Reference No:	2025/62/90827/E
Site Address:	120, Oxford Road, Gomersal, Cleckheaton, BD19 4HD
Description:	Erection of single storey rear extension, two storey side extension and first floor front extension with associated external alterations
Recommending Officer:	Nicole Helliwell

Officer Report

Proposal: Erection of single storey rear extension, two storey side extension and first floor front extension with associated external alterations.

Drawing No  
**25-007/ (AL)01**

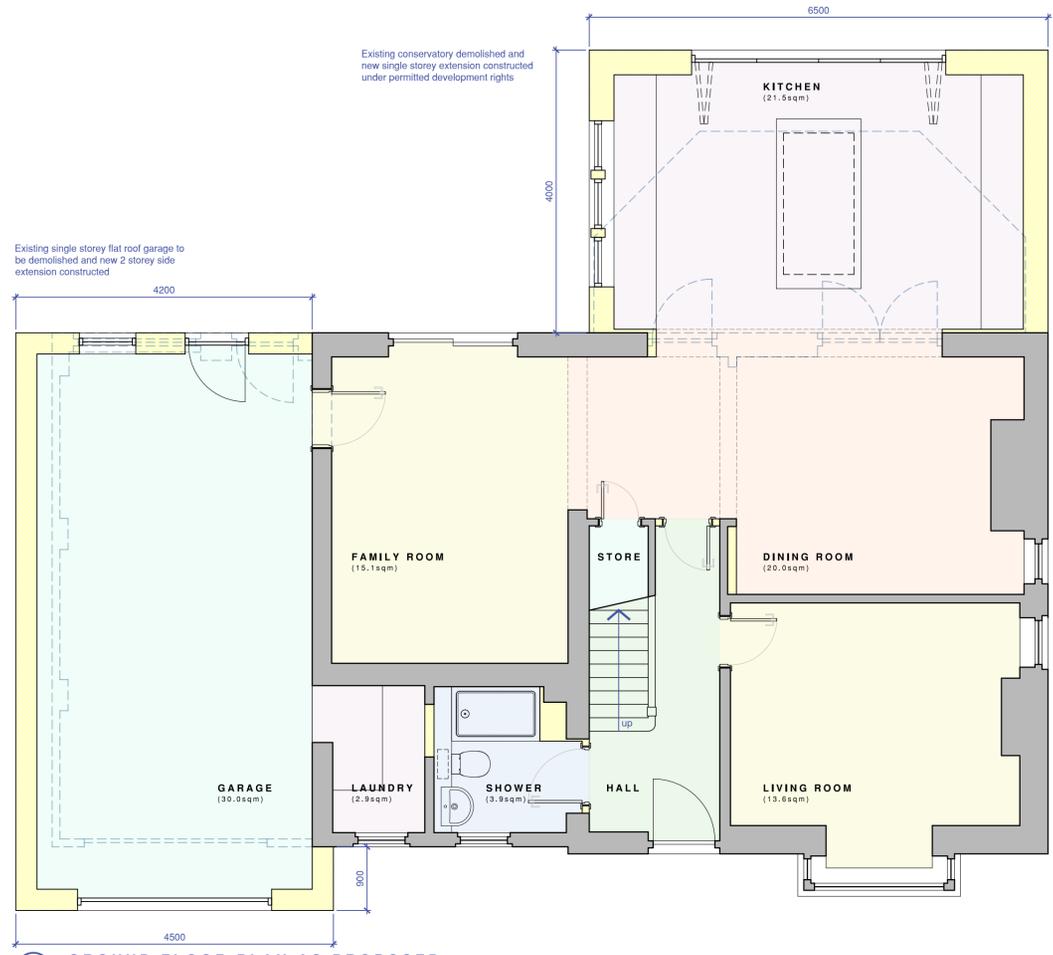
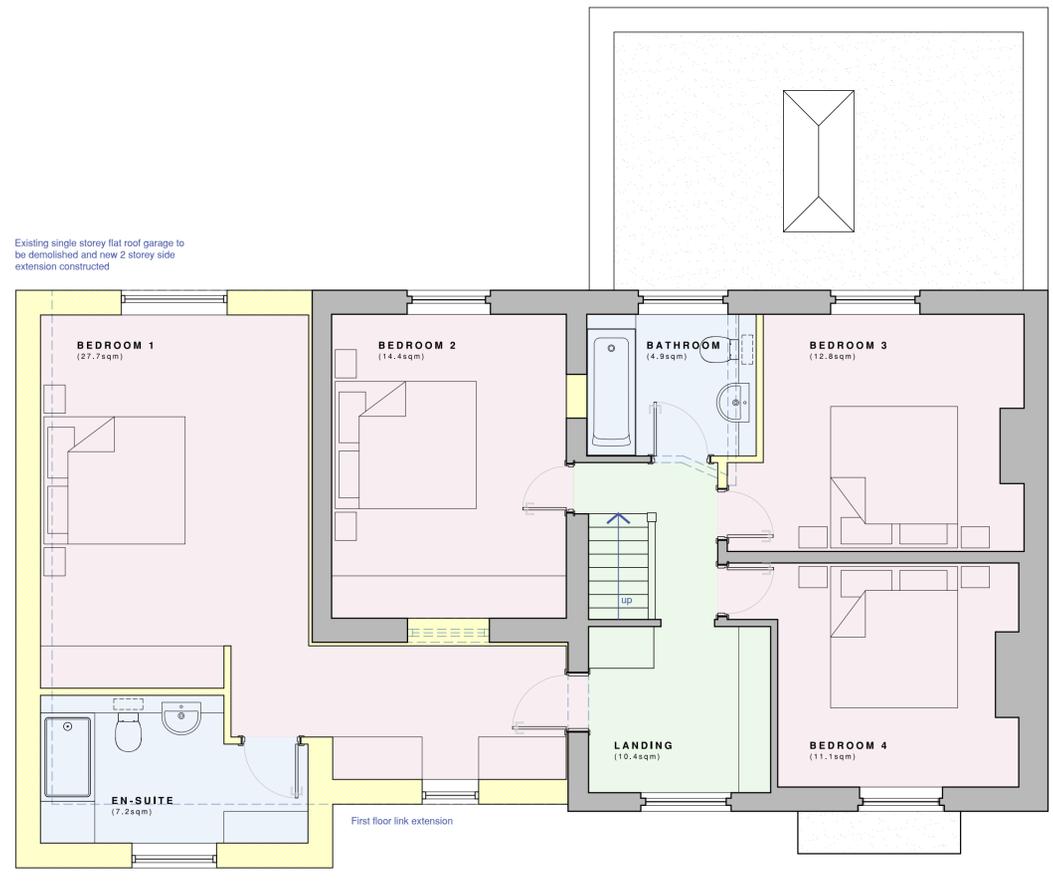
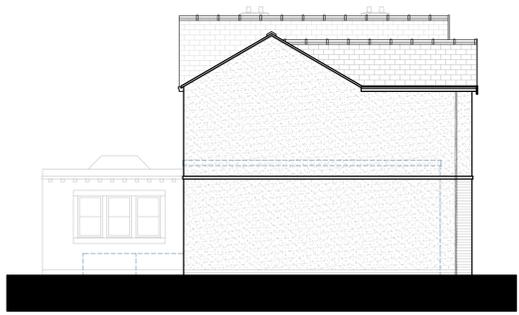
The proposed single storey extension would project 4m from the rear elevation of the original dwellinghouse. The enlargement would be faced in render to match the appearance of the host property. Although the extension would have a large width and would exceed the recommended 2.5m eaves height outlined within the SPD, it would appear subservient in relation to the original build and would maintain a sense of space within the plot. On this basis, the proposed development would respect the visual amenity of the host property and wider street scene and would be acceptable.

The proposed extension would project approximately 2.3m from the front elevation of the dwellinghouse and would sit above the existing single storey element of the property. The first floor extension would be constructed in render and would incorporate a dual-pitched roof finished slate. The enlargement would have an acceptable scale relative to the host property and would feature

a lower ridge line such that it would appear subservient. Furthermore, the extension would maintain at least a 1m gap to all property boundaries. Therefore, it is considered that the proposed development would respect the character and appearance of the host property and wider street scene.

The proposed two storey extension would project approximately 4.2m from the side elevation of the original dwellinghouse. The enlargement would be constructed from red brick and render for the external walls and would incorporate a dual pitched roof finished in slate to match the appearance of the host property. Although the enlargement would not be set back from the principal elevation, the extension would feature a lower ridge line which would enhance its subservience to the original build. Whilst it is noted that the enlargement would alter the scale and form of the dwelling, it would not represent an incongruous or unduly prominent feature. Furthermore, the extension would not maintain 1m to all property boundaries and would not give rise to any terracing effect. On this basis, it is considered that the proposal would not have any significant visual impact on the character and appearance of the host property and wider street scene.

The proposal seeks to apply render to the front and rear elevations of the dwelling. Although this amount of render would alter the appearance of the host property, it is noted that the dwelling currently incorporates render and render is also prevalent within the immediate street scene. Therefore, in this specific context, it is considered that the proposed alterations would not have any significant visual impact on the character and appearance of the host property and wider street scene.

122 Oxford Road is a two-storey detached property located north of the application site. The proposed two storey side extension would occupy a position approximately 1.4m from the common boundary shared with no.122. The enlargement would not surpass the front and rear elevations of the neighbouring dwelling and would accord with the 45 degree rule in relation to their ground and first floor fenestration. Furthermore, the proposed single storey rear extension would be sited approx. 9.8m from the shared boundary and would not extend beyond the rear elevation of no.122. On this basis, it is considered that the proposed development would be acceptable with regard to residential amenity.

4. The two storey side extension hereby approved shall be constructed from red brick and render for the external walls as shown on 'Plans and Elevations as Proposed' (reference no. 25-007/(AL)01). The roof shall be finished in slate to match the appearance of the original dwellinghouse. The materials of construction shall thereafter be retained for the lifetime of the development.
